MMC: FW: Shaws TCP (CMP)

Attached are our responses to the DPW's comments. Our approximate durations for each phase of work are as follows. Let me know if you would like any additional information.

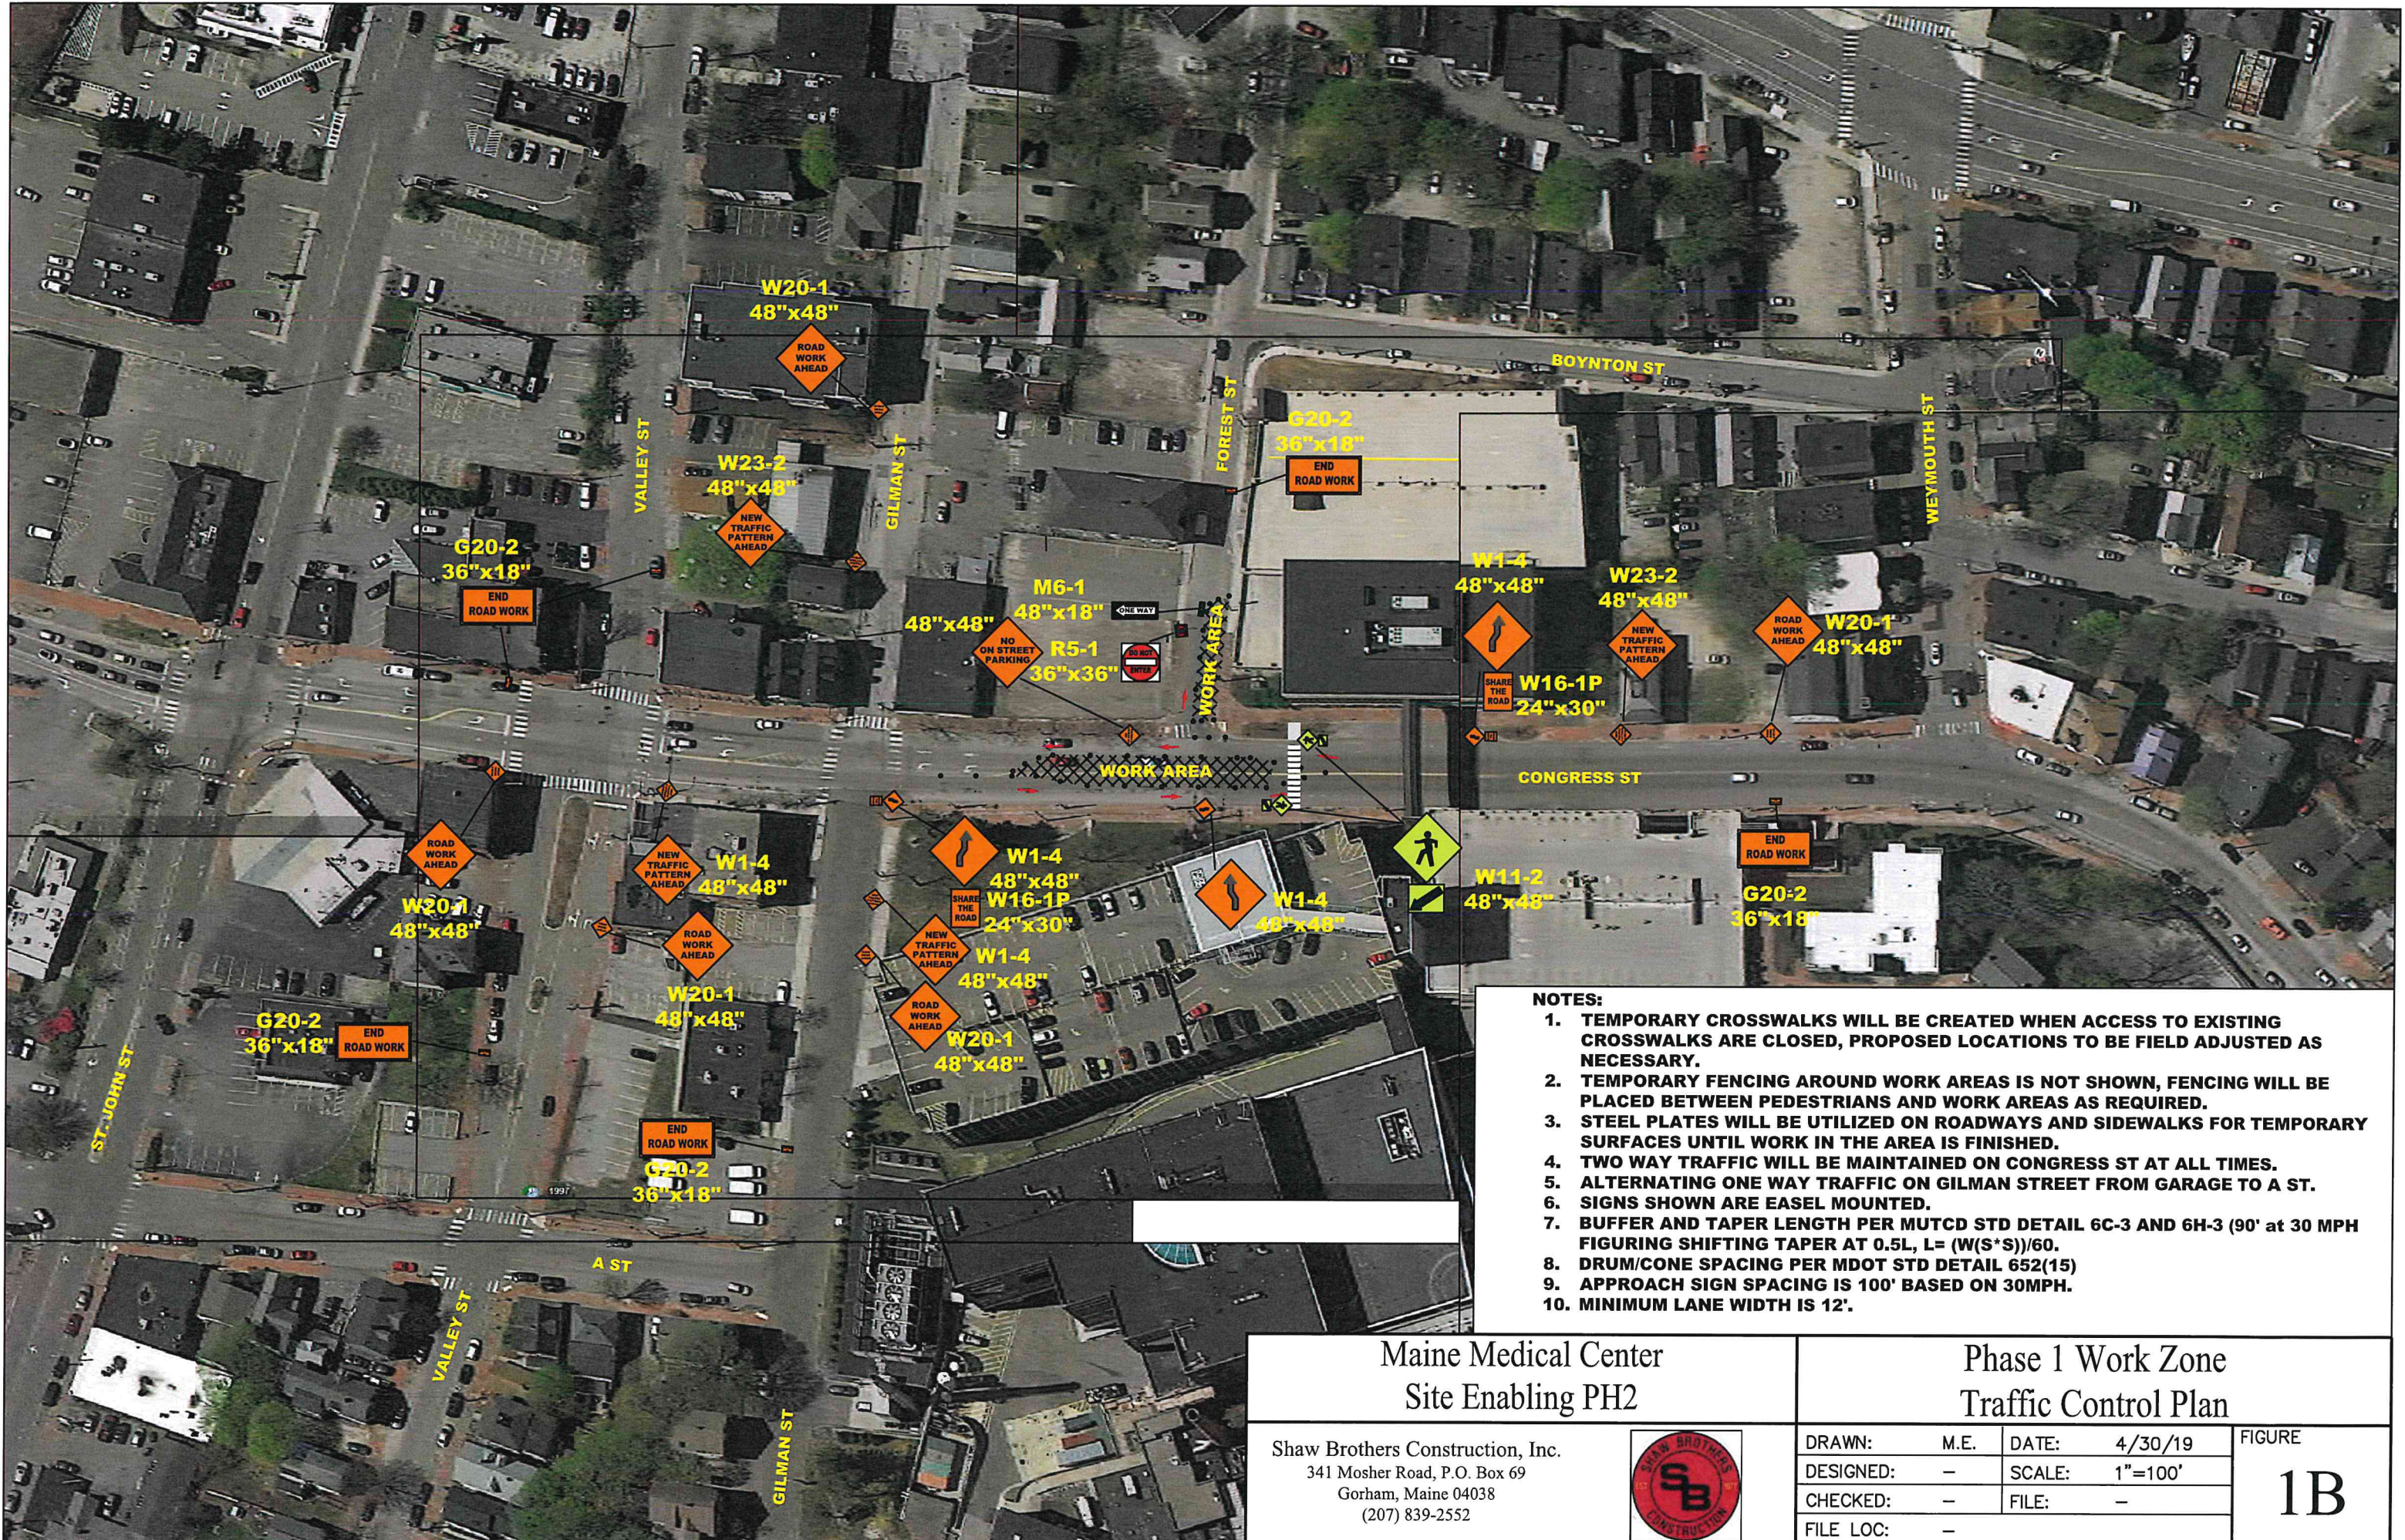
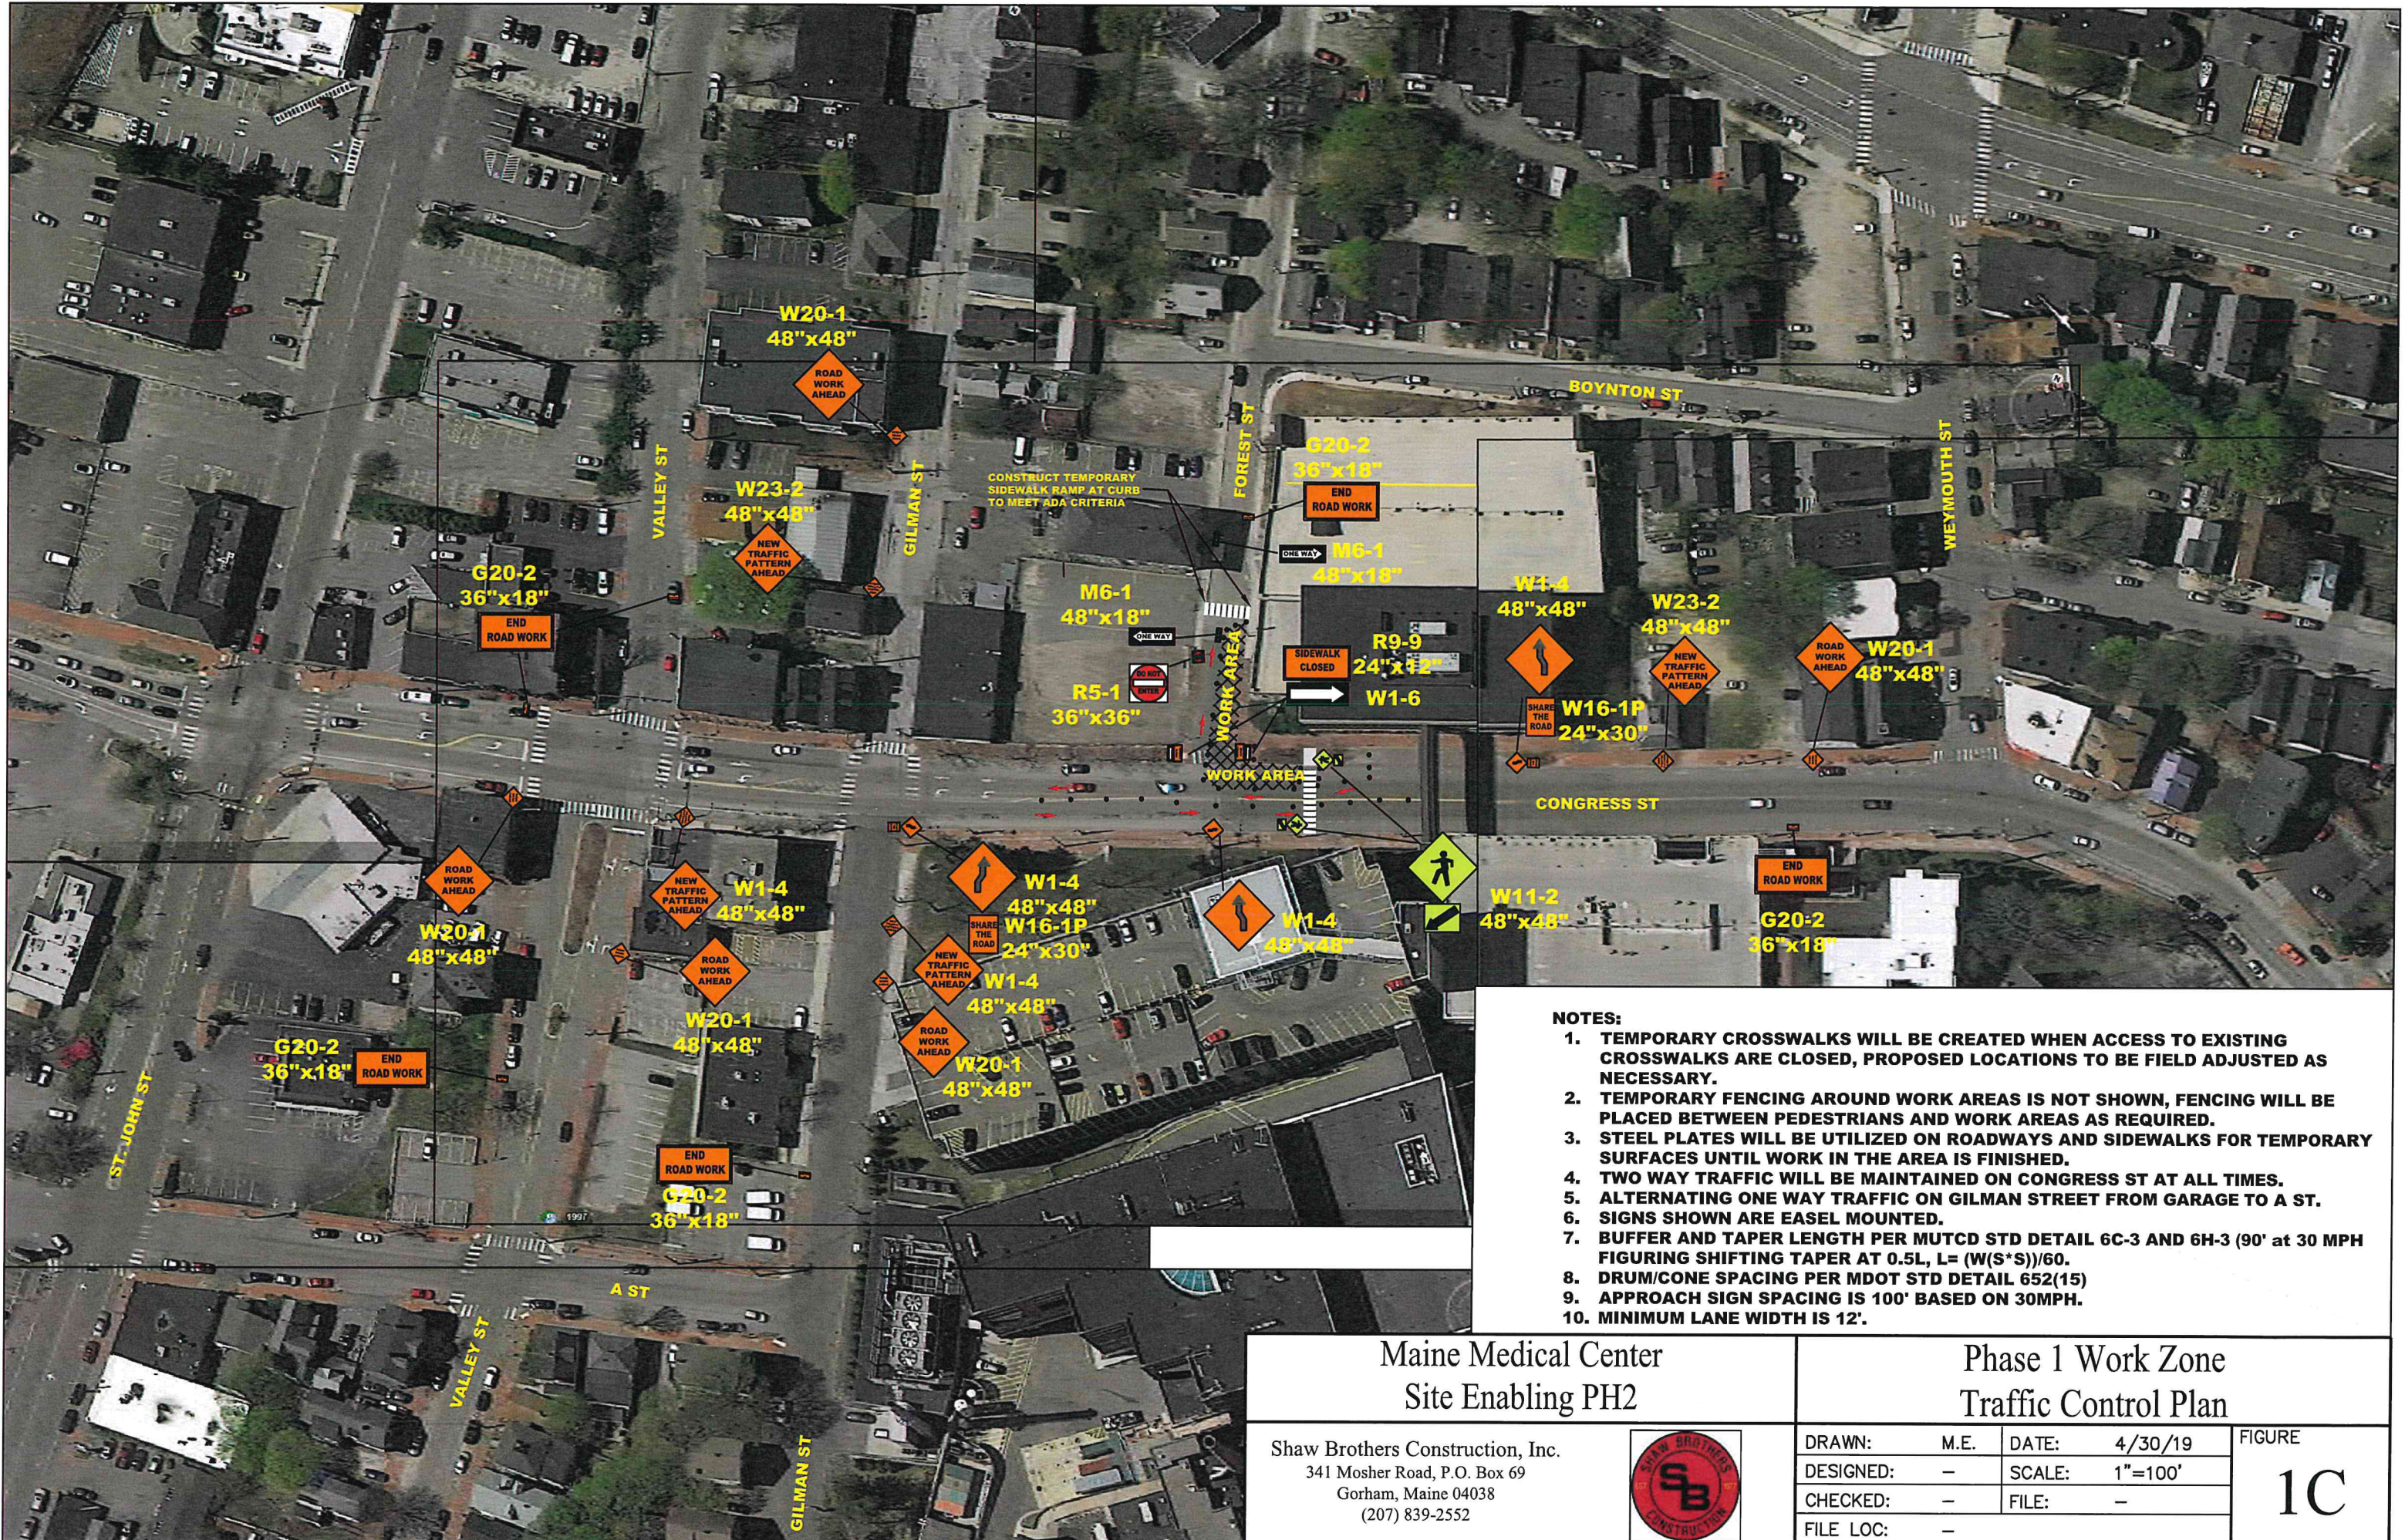
One basic comment from Tom Errico was re labeling the Shaw graphics with approximate timelines, but I don't believe this has been addressed (unless I'm missing something?). We do have timelines in the Turner documents, but these don't match up entirely with these plans. Can you guys address this quickly?

Phase #1: 3-4 weeks

Phase #2: 8-10 weeks

Phase #3: 4-6 weeks
